## DECISION DELEGATED TO HEAD OF PLANNING

**Application No:** H02-0386-25      **Applicant:** Ranbys Corner Ltd.  
**Proposal:** Erection of 5 No. Chalet Bungalows, new access road and relocation of prefabricated single garage to Ranby's Cottage - approved under H02-0217-18. Modification of Condition 2 to allow amendments to previously approved plans  
**Location:** Ranbys Corner 26 Chapel Street Crowland  
**Terminal Date:** 12th June 2025

drawing title
Proposed Site Plan

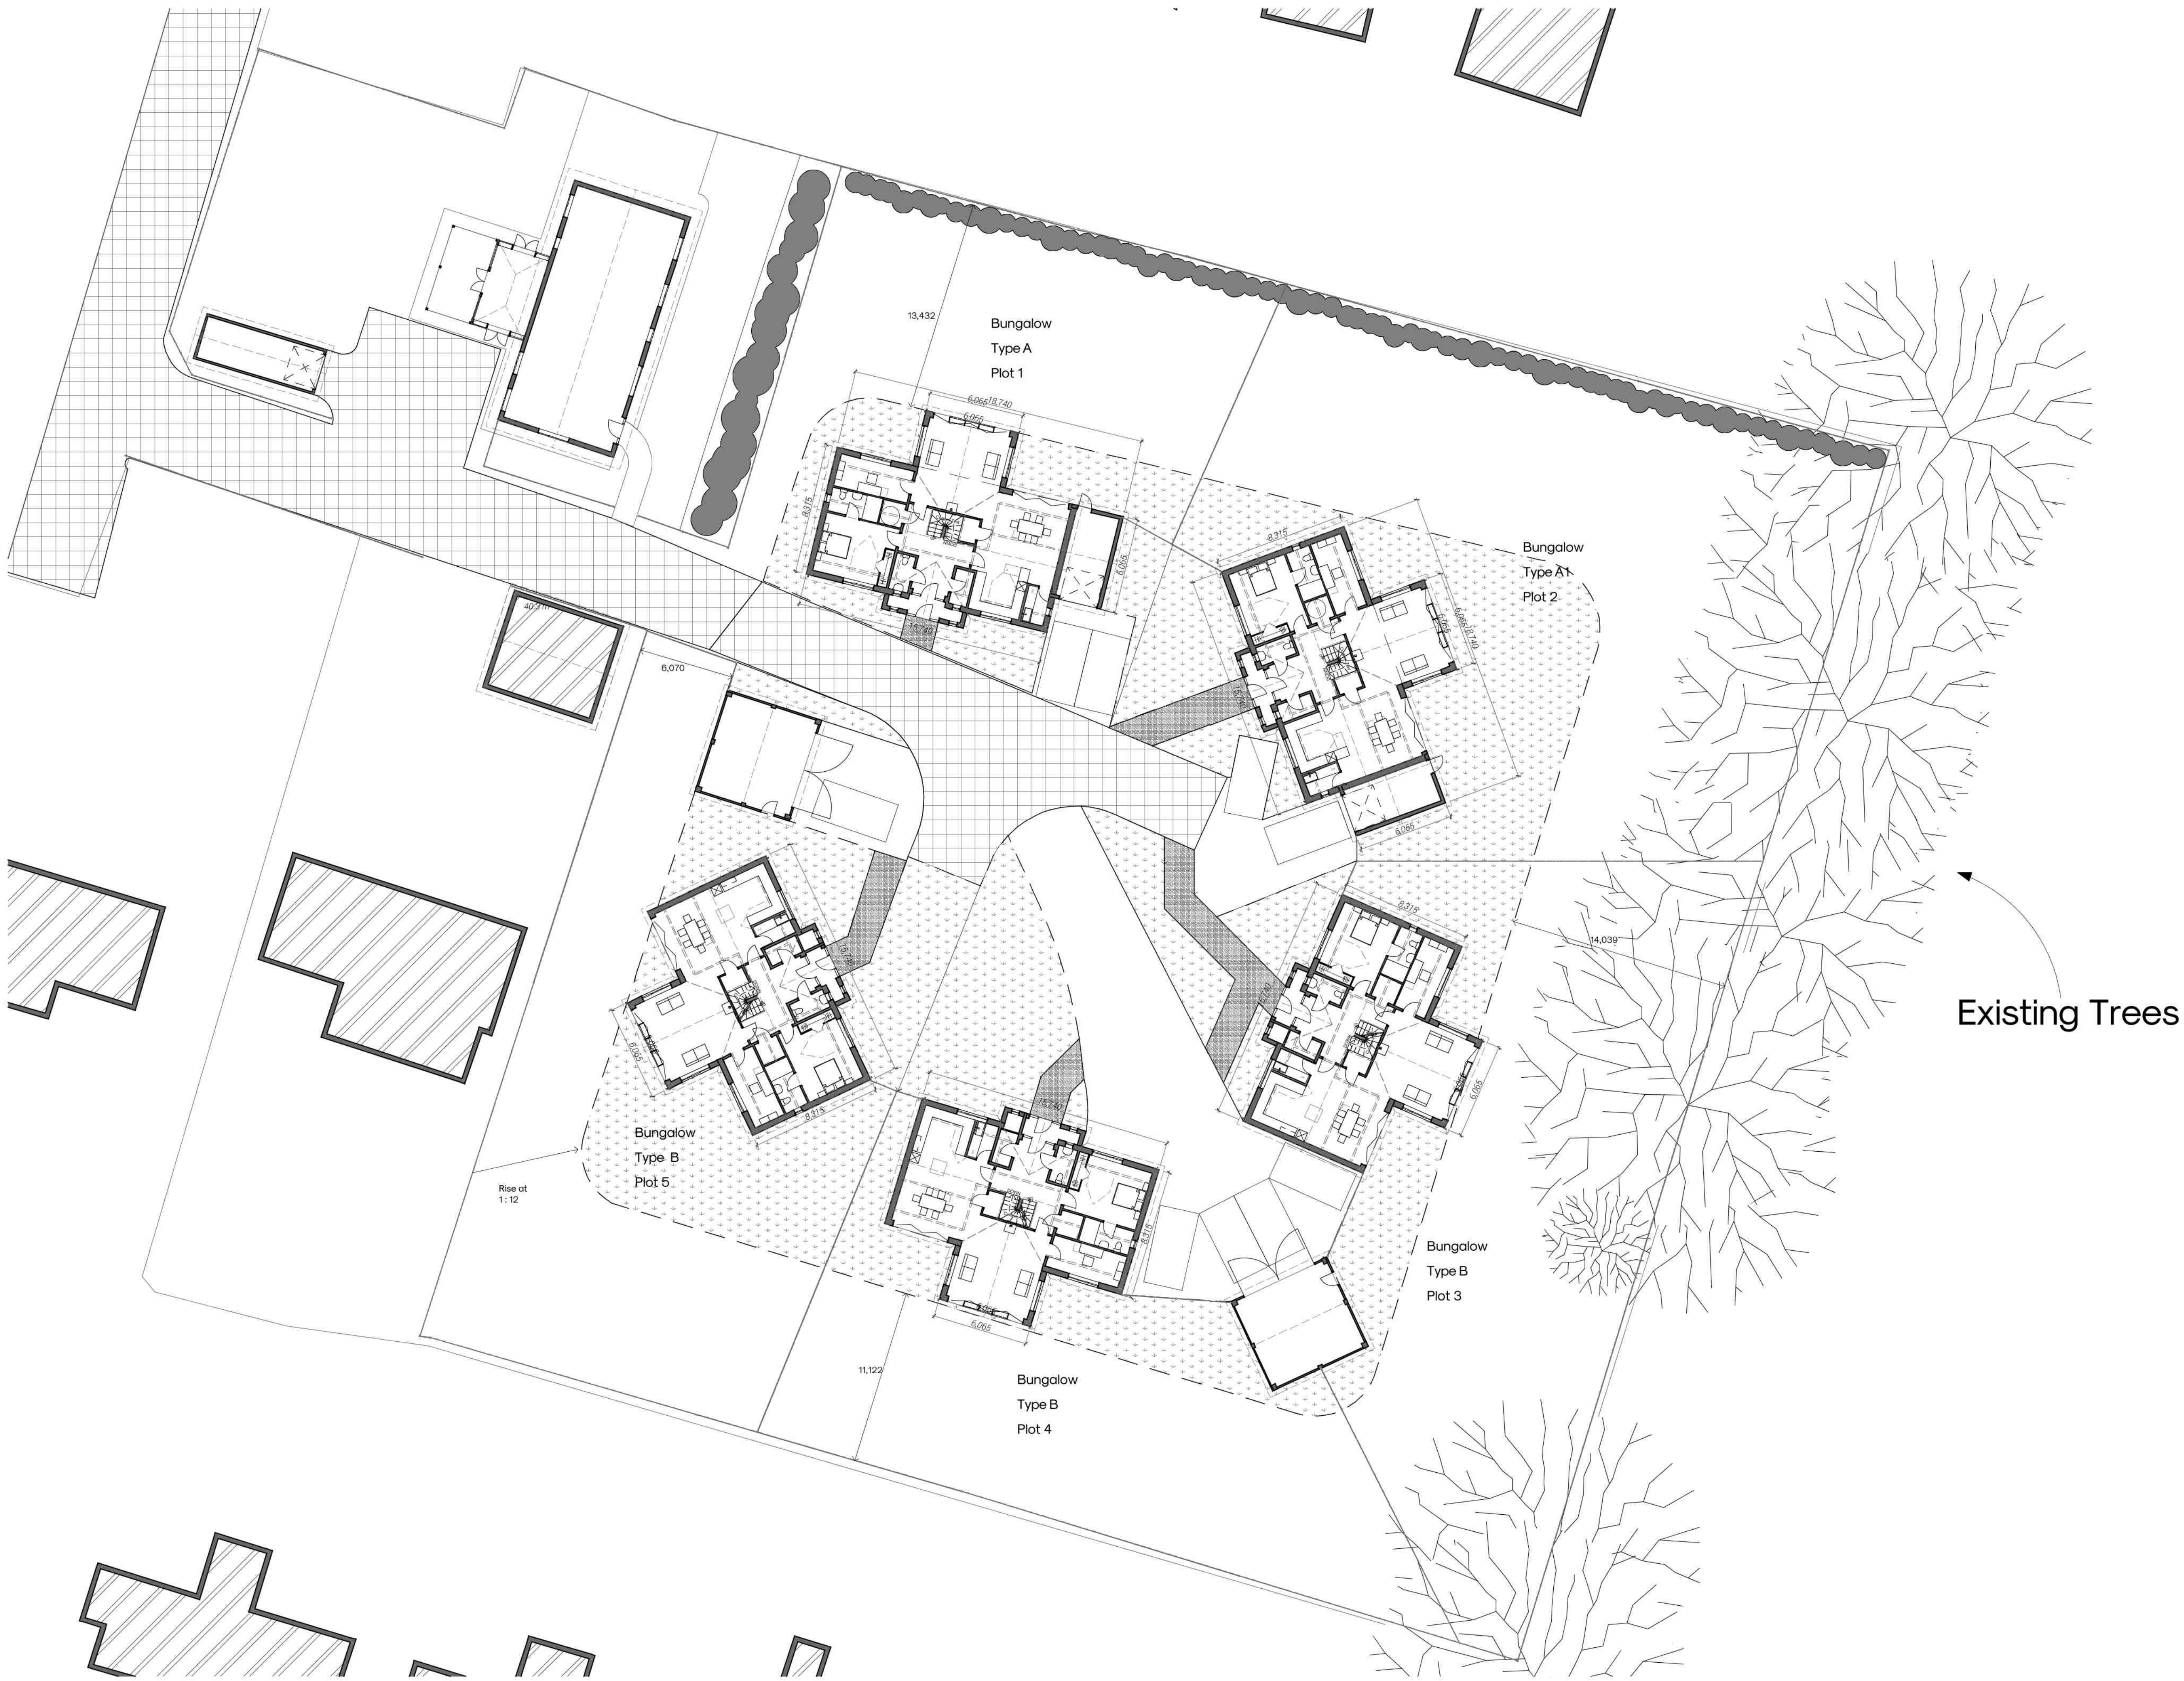
The proposed site plan contains a swept path analysis that demonstrates 'fire appliance tracking'. The plan shows that a marginally wider access is required in order to achieve the space. The plan also shows a refuse bag collection area located to the southern boundary of the access. All of these changes are within the red line boundary associated with H02-0217-18.

However, the location of the 'refuse bag area' would appear to have potential to block this access somewhat on collection day if not stacked correctly, given the nature of simply leaving the bags in an ad-hoc fashion. A more formalised collection area should be established to prevent the bags falling into the access. Condition 9 of the original permission reserved the details of such a facility. This condition will be reattached.

The only change to the dwellings are to plot 1, which is reorientated slightly (anti-clockwise) to allow for service vehicle to enter the site. This has limited additional considerations therefore as regards amenity impacts, through overshadowing/overbearing and visual intrusion, upon neighbouring properties. Especially given that separation distances are retained in line with the previously approved scheme.

The applicant has also proposed the location of a refuse collection area. This is just shown on plan to be an area where bags are left on collection days, this is located to the rear of two properties accessed from Chapel Street.

belonging to 5 number dwellings at the rear of their properties would give rise to pollution effects through odour. It is likely that a more appropriate (fixture/structure) is required to contain the refuse whilst waiting for collection or alternatively, as per condition 9 (of H02-0217-18) details of a private means of waste collection are submitted to and agreed in writing with the LPA.

The proposal represents minor alterations to a previously approved scheme. Whilst the changes to the access and reorientation of plot 1 are acceptable, the location and 'type' of the open refuse storage is not considered acceptable and will be controlled through planning conditions.
